# KITTITAS COUNTY

## DEPARTMENT OF PUBLIC WORKS

### MEMORANDUM

**TO:** All Staff  
**FROM:** Public Works Plan Review Team  
**DATE:** November 16<sup>th</sup>, 2023  
**SUBJECT:** SP-23-00008 Rarden

RARDEN SHORT PLAT
 A PORTION OF THE EAST 1/2 OF SECTION 20,
 TOWNSHIP 20 NORTH, RANGE 14 EAST, W.M.,
 KITTITAS COUNTY, WASHINGTON

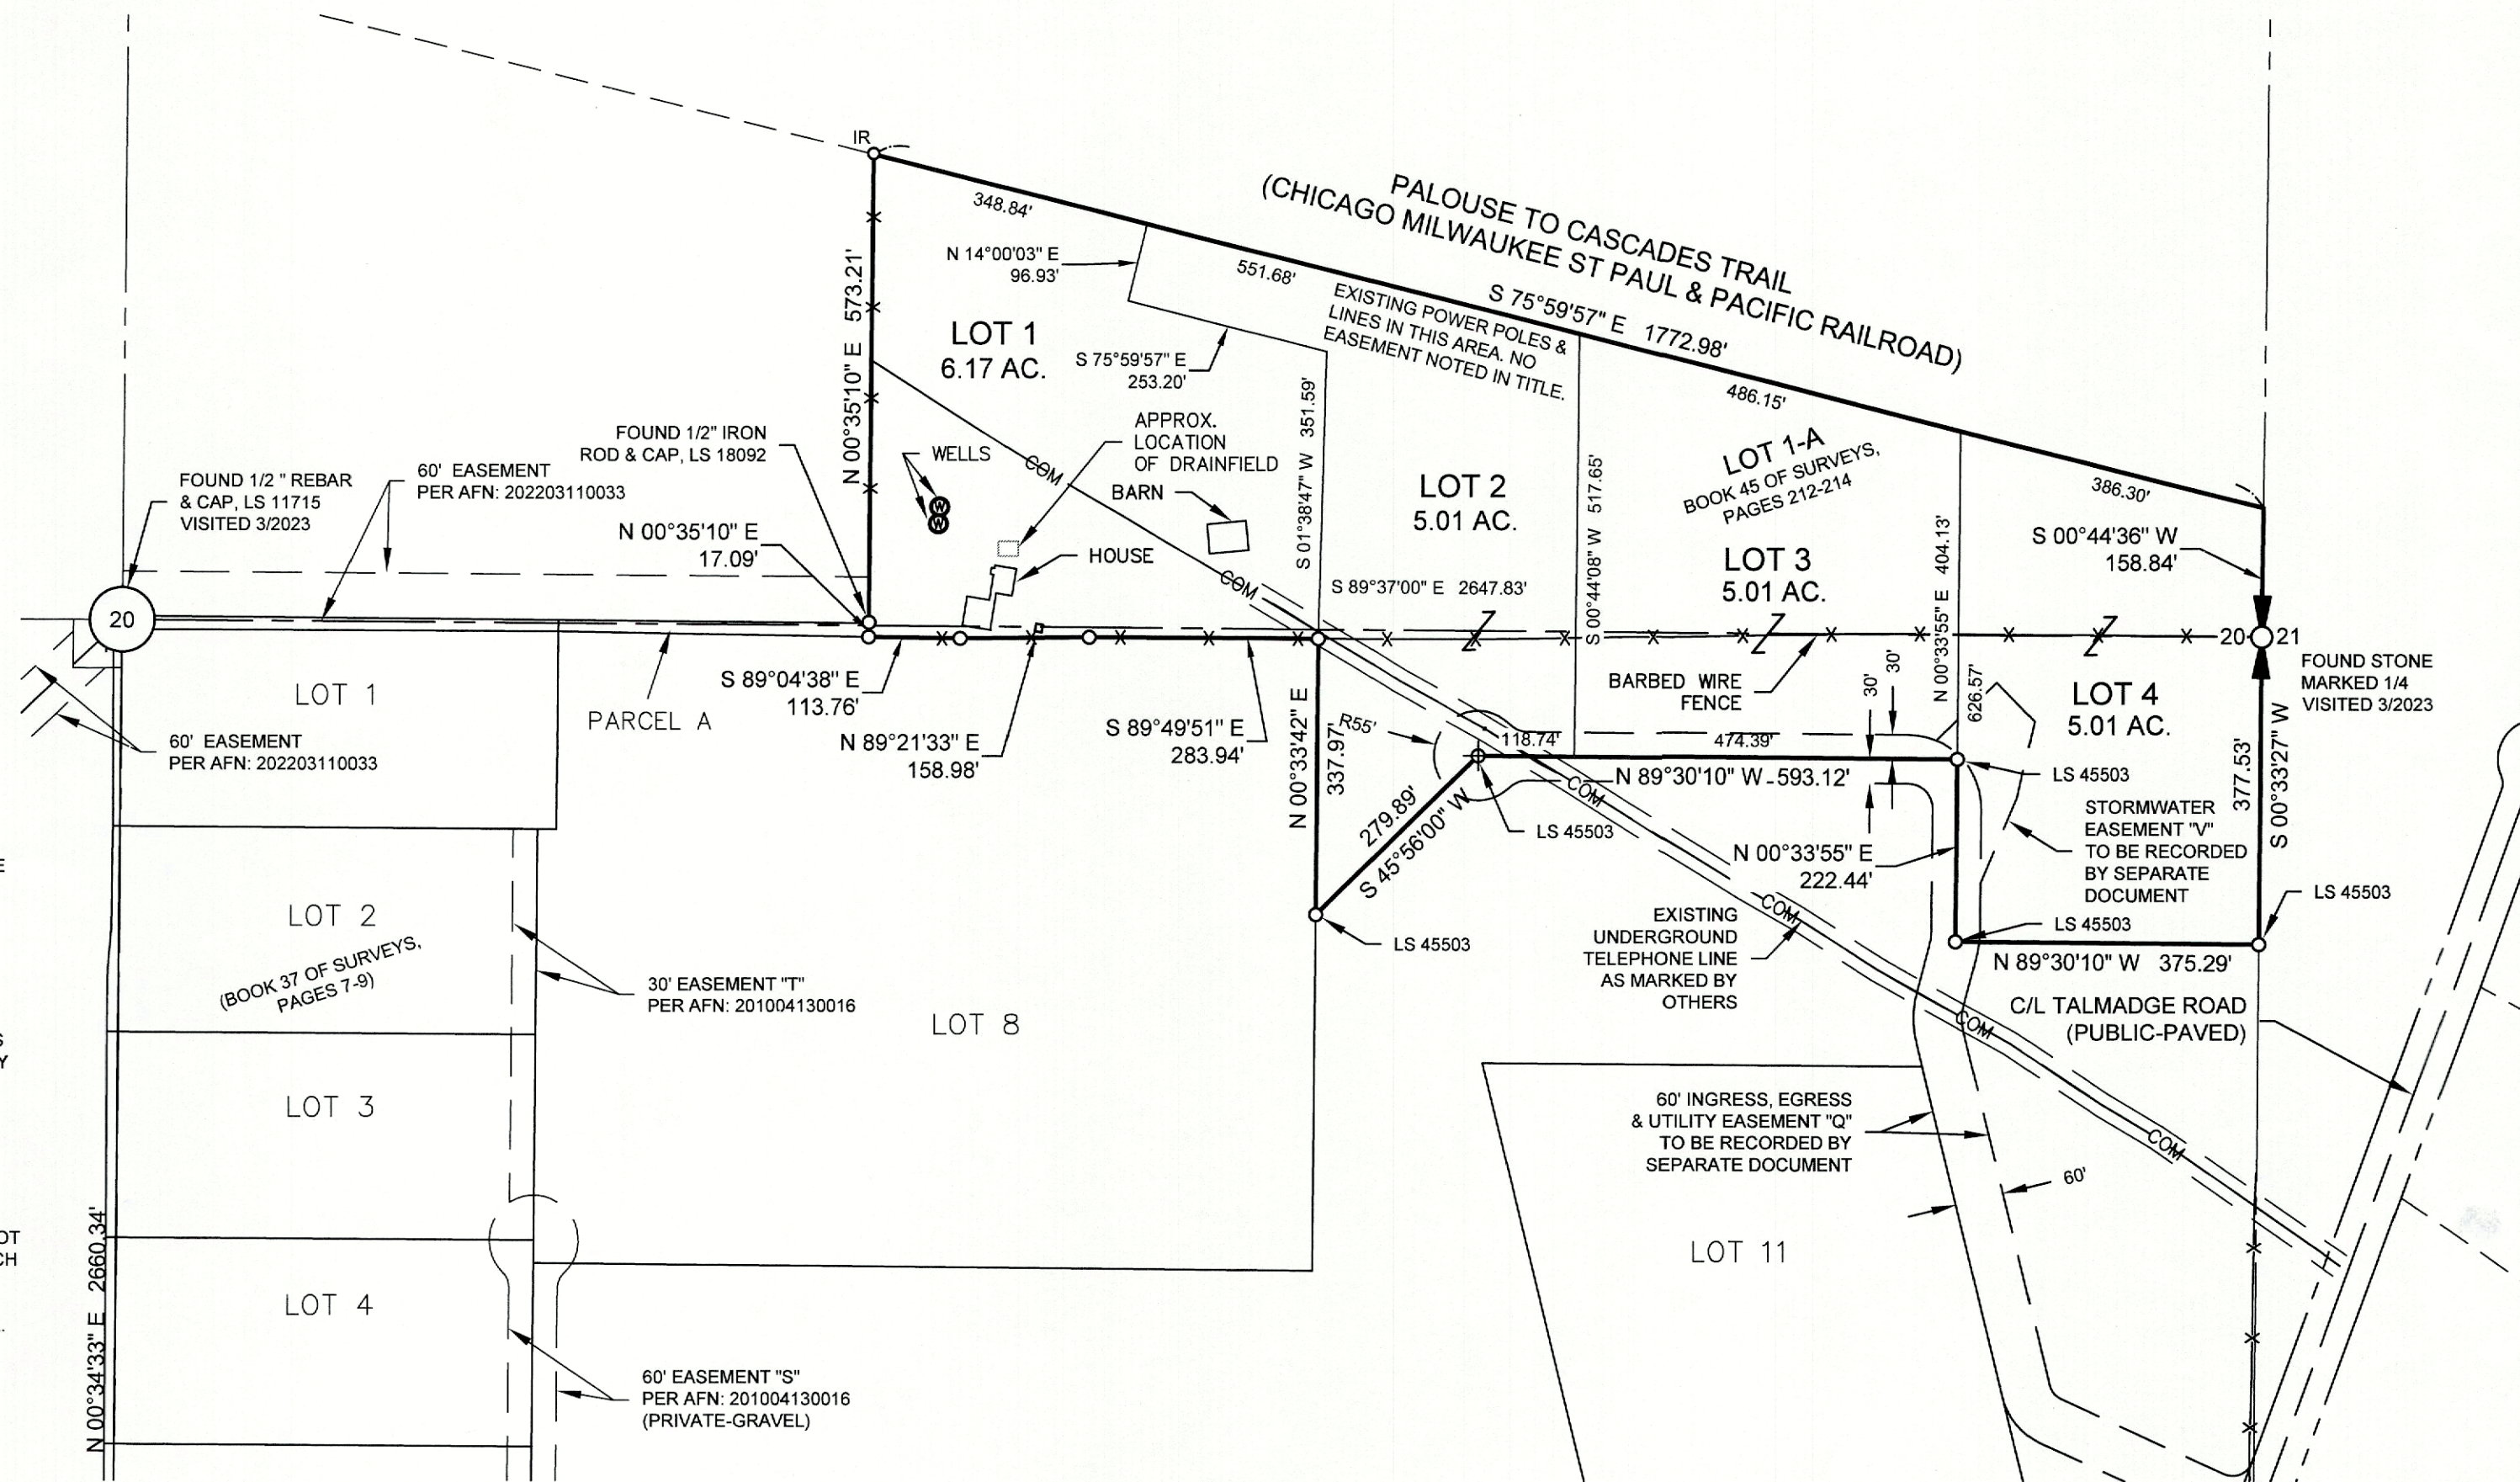
<p><b>ENGINEERING</b></p>	<p>Grading Permit GP-23-00011 was issued on 7/28/23. Please call for an inspection when the project is complete. (CC)</p>
<p><b>SURVEY</b></p>	<p>The following will need to be addressed prior to Final Short Plat approval:</p> <ol style="list-style-type: none"> <li>1. Per Note 1, Sheet 1, access to Lot 1A is Via a private easement. This should be changed to Lot 1, and the easement(s) shown in full. If there are gaps (as shown) in the NW1/4 and SE1/4 of the section, note that access is by prescription in these areas.</li> <li>2. Notes 6, 8 and 9 all reference different basis of bearings statements, and make references to Lots not shown on the face of the Short Plat.</li> </ol>

<p>Please resolve, and if multiple Basis of Bearing were utilized, please include the rotation and direction (clockwise or counterclockwise), that was used to put it in the final rotation shown on the map.</p> <p>3. The SW'most corner of Lot 2 will need to be set and shown on the face of the Final Survey.</p>
<b>TRANSPORTATION CONCURRENCY</b>	<p>A Transportation Concurrency Management Application has been submitted. Permit #: TC-23-00005 This permit will need to be finalized before final approval.</p>
<b>FLOOD</b>	<p>Parcel # 415436 is not located in the FEMA identified special flood hazard area (100-year floodplain). (SC)</p>
<b>WATER MITIGATION/ METERING</b>	<p>The following comments outline the requirements for legal availability of water and metering for the proposed short plat:</p> <p>The applicant must provide legal water availability for all new uses on the proposed lots of this project, which can be provided through mitigation certificates. Prior to final plat approval and recording, the following conditions shall be met:</p> <p>In accordance with KCC Chapter 13.35.027, the applicant shall provide one of the following documents before final plat approval:</p> <ol style="list-style-type: none"> <li>1. A letter from a water purveyor stating that the purveyor has adequate water rights and will provide the necessary water for the new use;</li> <li>2. An adequate water right for the proposed new use; or</li> <li>3. A certificate of water budget neutrality from the Department of Ecology or other adequate interest in water rights from a water bank.</li> </ol> <p>All applicants for land divisions shall also submit information on "proximate parcels" held in "common ownership" as those terms are defined in WAC 173-539A-030 and otherwise demonstrate how the proposed new use will not violate RCW 90.44.050 as currently existing or hereafter amended.</p> <p>Failure to obtain mitigation before commencement of an activity requiring mitigation shall be a code violation subject to enforcement under Title 18 KCC.</p> <p><b>Final Plat Notes</b></p> <p>The following notes shall be placed on the face of the plat:</p> <p>C-1 "Metering is required for all new uses of domestic water for residential well connections and usage must be recorded in a manner consistent with Kittitas County Code Chapter 13.35.027 and Ecology regulations."</p> <p>C-2 "The approval of this division of land provides no guarantee that use of water under the ground water exemption (RCW 90.44.050) for this plat or any portion thereof will not be subject to curtailment by the Department of Ecology or a court of law." (SC)</p>
